From: Thomas Callaway
Sent: 16 May 2014 11:34
To: Planning.Responses
Subject: RE: Planning Consultation on: A/42/14/PL

APPLICATION **A/42/14/PL**

Site Address: Roundstone Farm Littlehampton Road Ferring BN12 6PW

Description of Works: General purpose steel framed agricultural machinery storage building

Typical Section

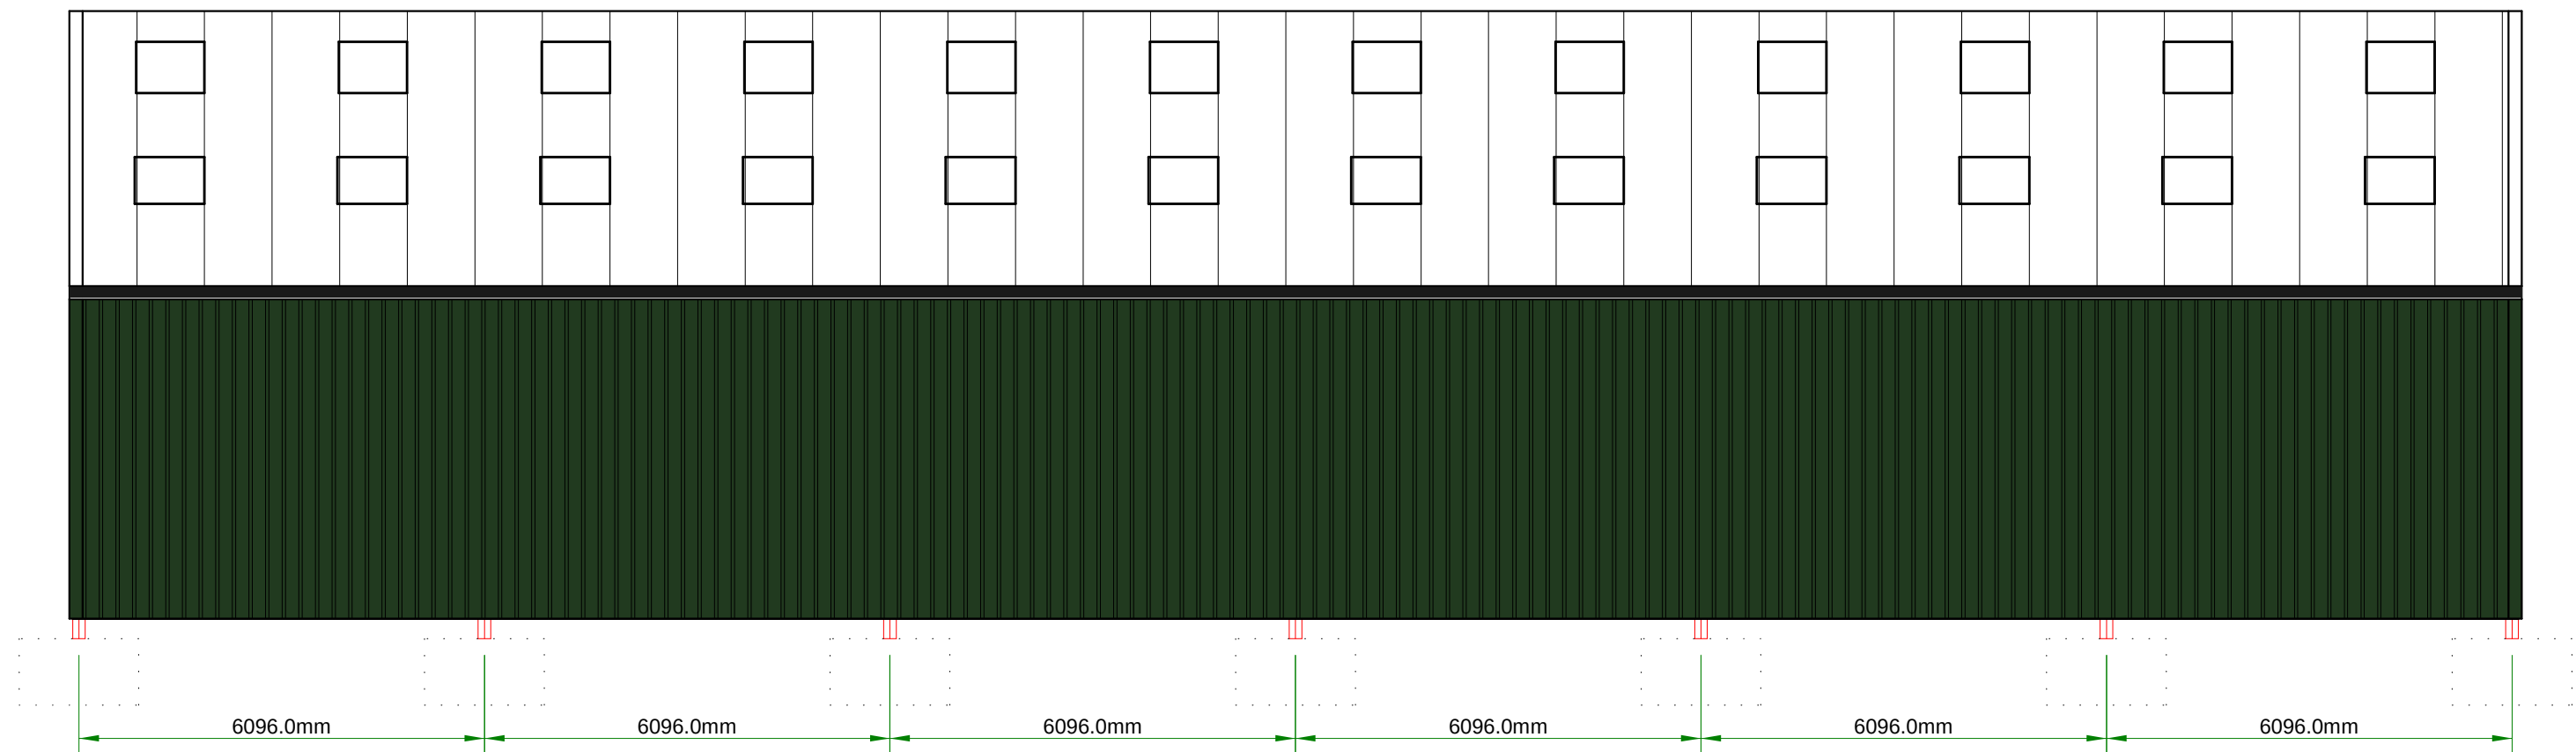
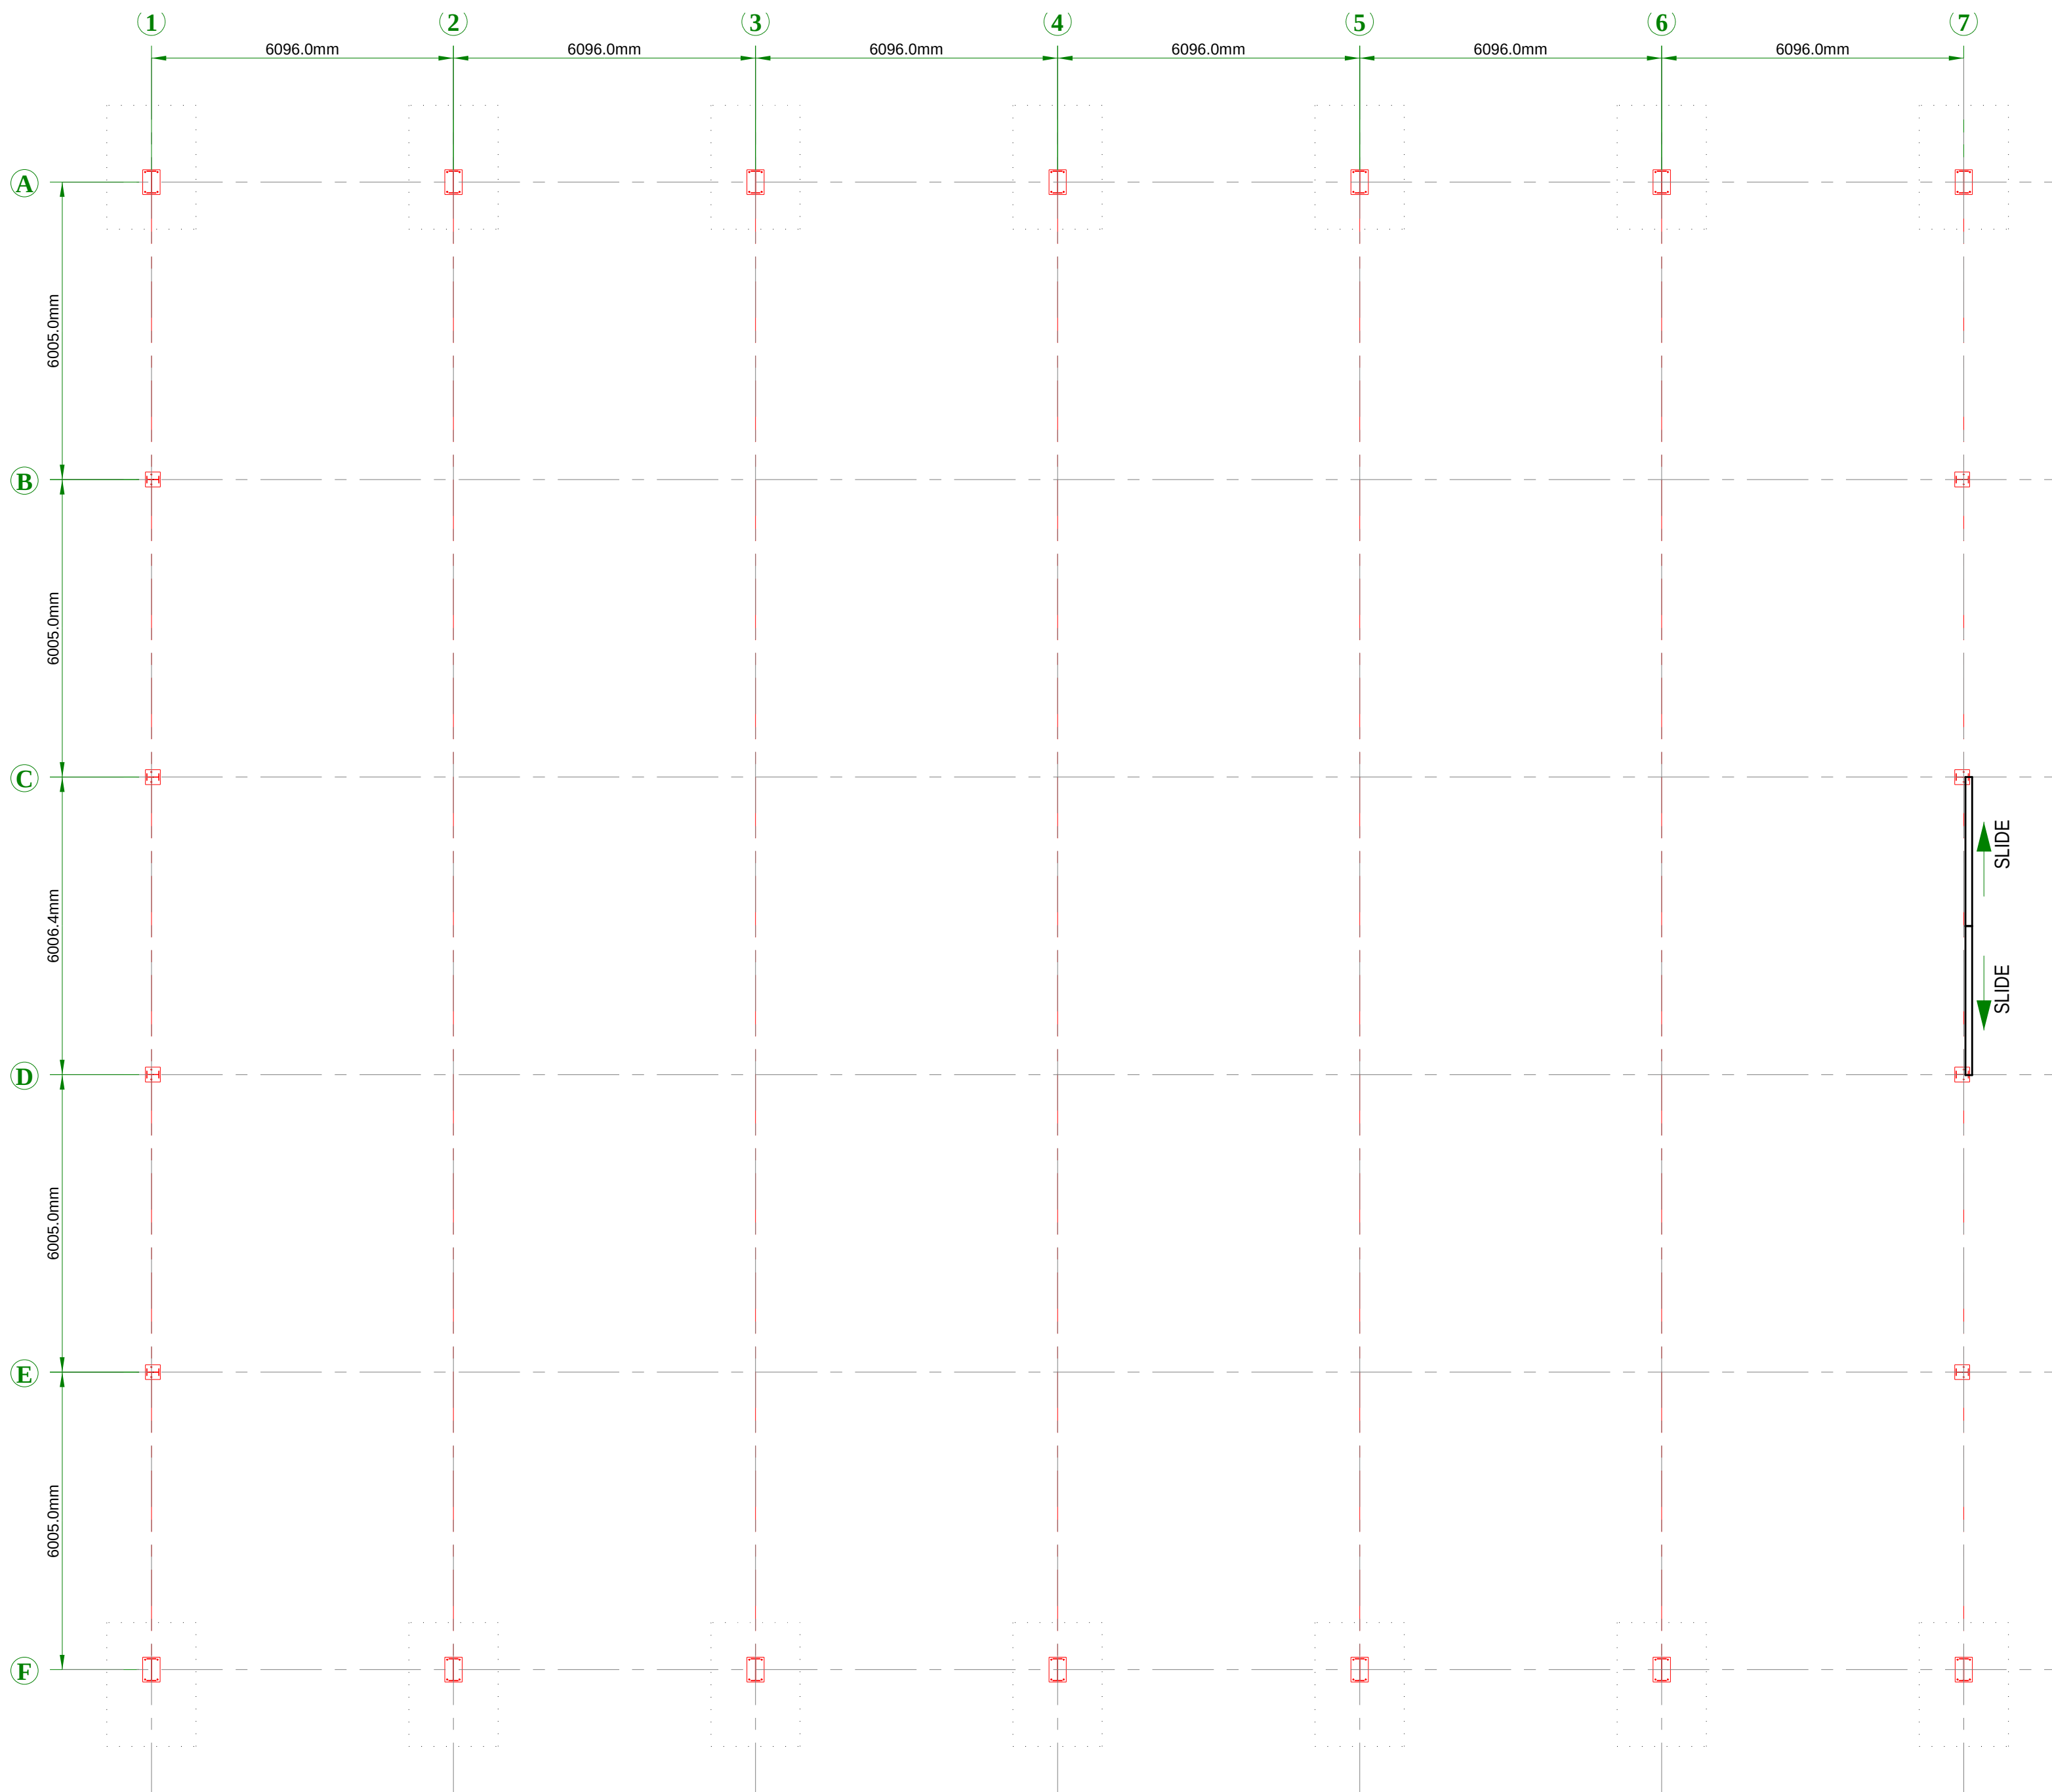
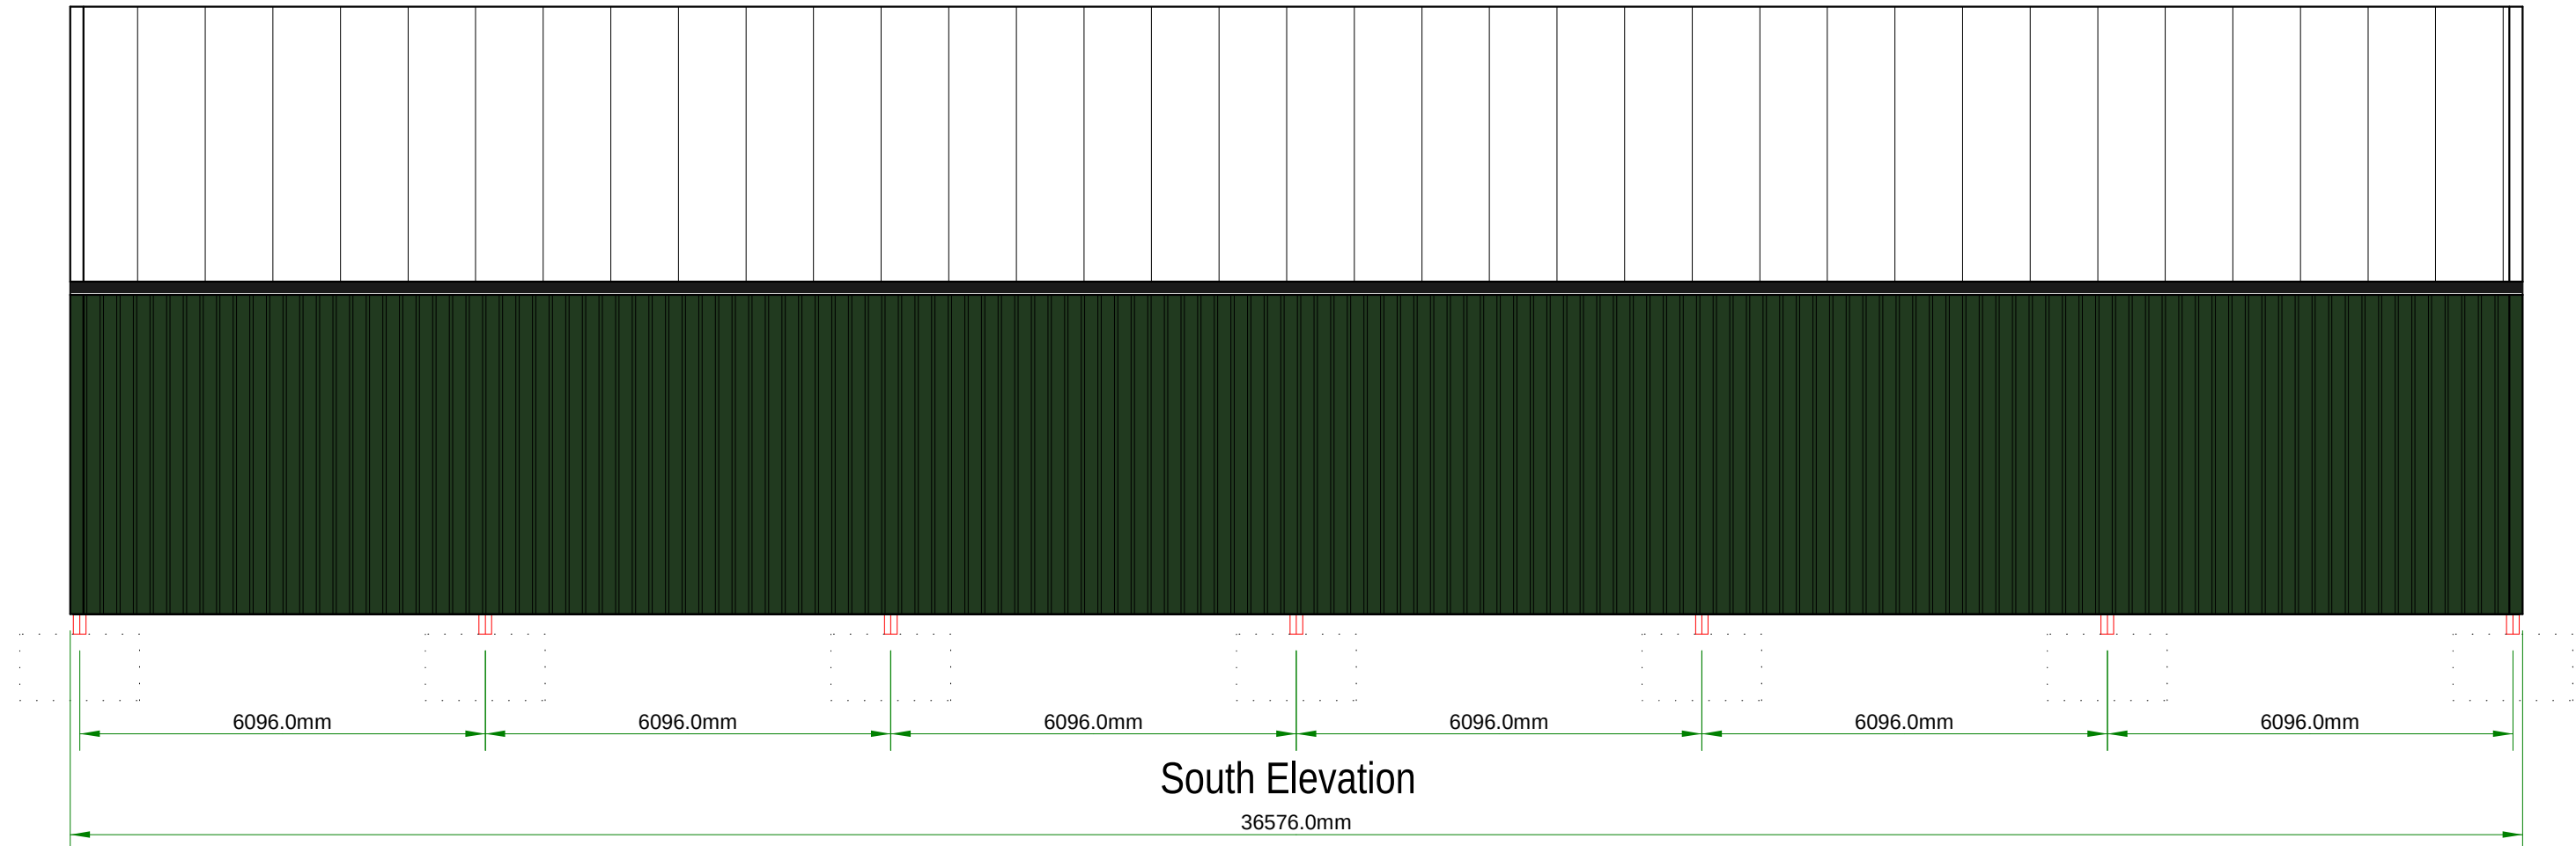
The applicant states that surface water will be discharged to soakaway.

Please apply standard conditions ENGD2A.

Infiltration rates for soakage structures are to be based on percolation tests undertaken in the winter period and at the location and depth of the proposed structures. The percolation tests must be carried out in accordance with BRE 365, CIRIA R156 or a similar approved method and cater for the 1 in 10 year storm between the invert of the entry pipe to the soakaway, and the base of the structure. It must also have provision to ensure that there is capacity in the system to contain below ground level the 1 in 100 year event plus 30% on stored volumes, as an allowance for climate change. Adequate freeboard must be provided between the base of the soakaway structure and the highest recorded annual groundwater level identified in that location.

Any SuDS or soakaway design must include adequate groundwater monitoring data to determine the highest winter groundwater table in support of the design. The applicant is advised to discuss the extent of groundwater monitoring with the Council's Engineers. Supplementary guidance notes are also enclosed for information.
